EN010117: Application by Rampion Extension Limited for the Rampion 2 Offshore Wind Farm

Horsham District Council response to The Examining Authority's Written Questions and requests for information issued on Wednesday 3 April 2024

Deadline 3: HDC Response and Information Requested to the Examining Authority's written questions and requests for information.

Date: 24th April 2024

Figure 19.1.1 Comparison of Measured Road-NOx with Unadjusted Modelled Road-NOx

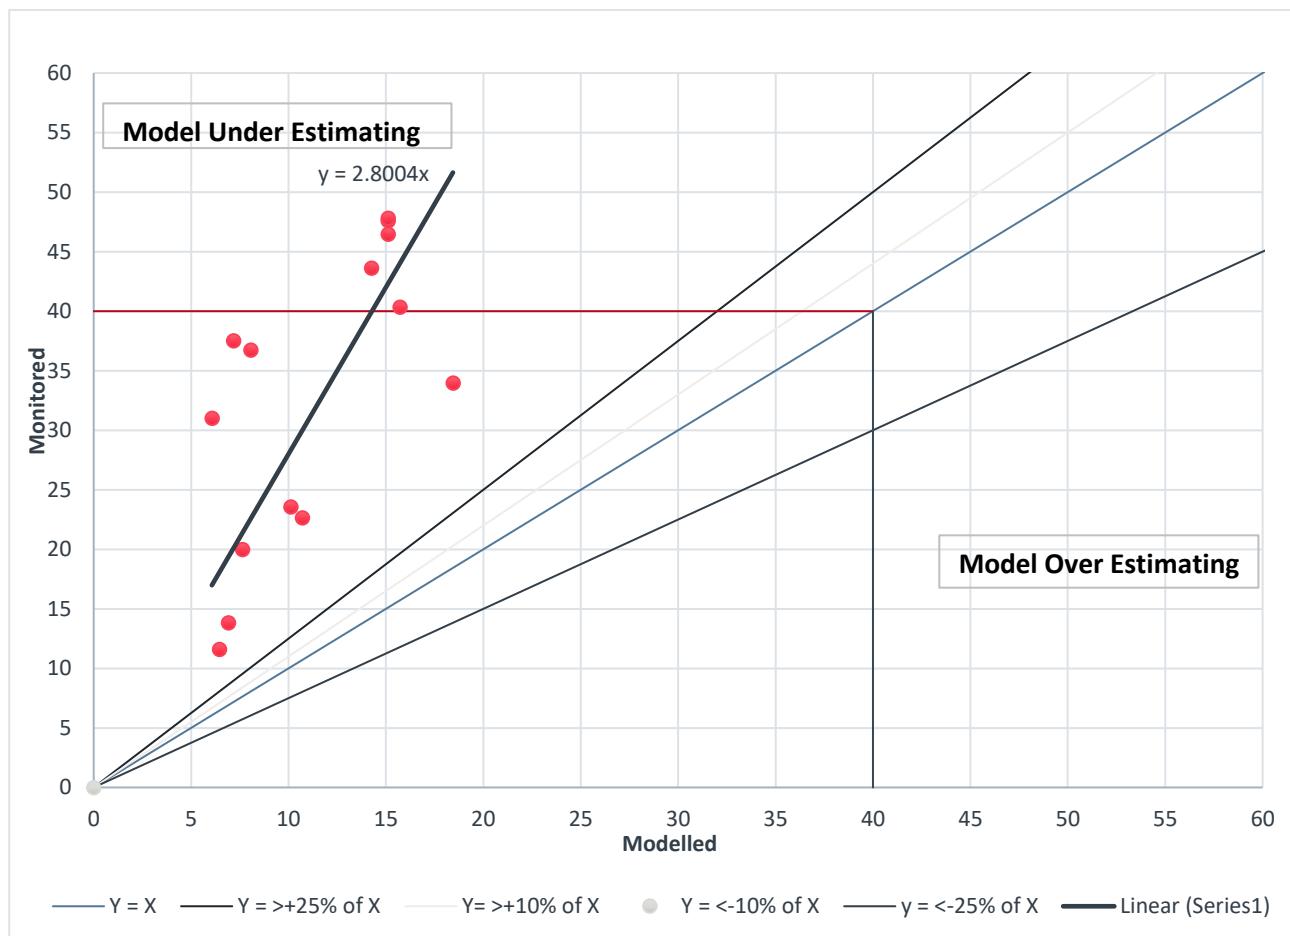
<p>No independent monitoring of the Code of Construction Practice is required under commitment 22. The implementation and operation of the construction activities with respect noise, vibration and dust should be subject to independent audit and monitoring by a competent person. This will provide transparency and community reassurance that traffic impacts are being minimised. This audit and monitoring should be funded by the developer to reduce the burden on the LPA.</p> <p>HDC would welcome an independent auditing of the monitoring undertaken by the Transport Coordination Officer (TCO) to ensure community confidence and to police the traffic passing through Cowfold AQMA so it does not become higher than 25% over the life of the project.</p>
			<p><i>HDC LIR Comment:</i> Paragraph 11.29 HDC has concerns of the modelling results for Cowfold AQMA. Details are therefore required of the model set up:</p> <ul style="list-style-type: none"> • For which construction year the model was set up? • What was the AADT considered? It is understood that even with HGV reroute in place, 25% will still go through Cowfold AQMA. The concern is that the Assessment Scenario includes assumptions on HGV routing which may not materialise for project implementation. <p><i>Applicant's response:</i> The air quality modelling for Cowfold Air Quality Management Area (AQMA) was updated and provided in Chapter 32: ES Addendum, Volume 2 of the Environmental Statement [REP1-006]. The updated assessment modelled the second year of construction; the year with the highest development traffic according to the revised traffic data for the Proposed Development presented in Chapter 32: ES Addendum, Volume 2 of the ES [REP1-006]. The AADT used takes into account the heavy goods vehicle (HGV) routing through the Cowfold AQMA. The updated traffic data did not change the outcome of the assessment provided in Chapter 19: Air quality, Volume 2 of the ES [APP-060].</p> <p>HDC Comment: HDC has concerns regarding modelling results, as Cowfold worst-location (DT37) is still underpredicting by 24.5% even after modelling results were adjusted.</p>

<p>There wasn't any breach of annual mean NO2 objective at HDC monitoring location in the past four years (2019-2022), but site DT37 (Cowfold 7n) reached a concentration of 36.1µg/m³ in 2019, which is within 10% of the annual mean objective. As stated on TG22: The fractional bias of the model may be used in order to identify if the model shows a systematic tendency to over or under predict. However, care should be taken when using this statistic particularly where local authorities are concerned about the performance of the model at concentrations close to the air quality objective being assessed. The fractional bias provides the tendency of the whole model to under or over predict, and local authorities should consider the performance at each site. The correlation coefficient is used to measure the linear relationship between predicted and observed data. A value of zero means no relationship and a value of 1 means absolute relationship. The correlation coefficient for the model after adjustment is 0.595, which is distant to the ideal value of 1.0. HDC concern is that with this monitoring location being severely underpredicting, the conclusion of AQ impacts at the worst-location will not be valid.</p>
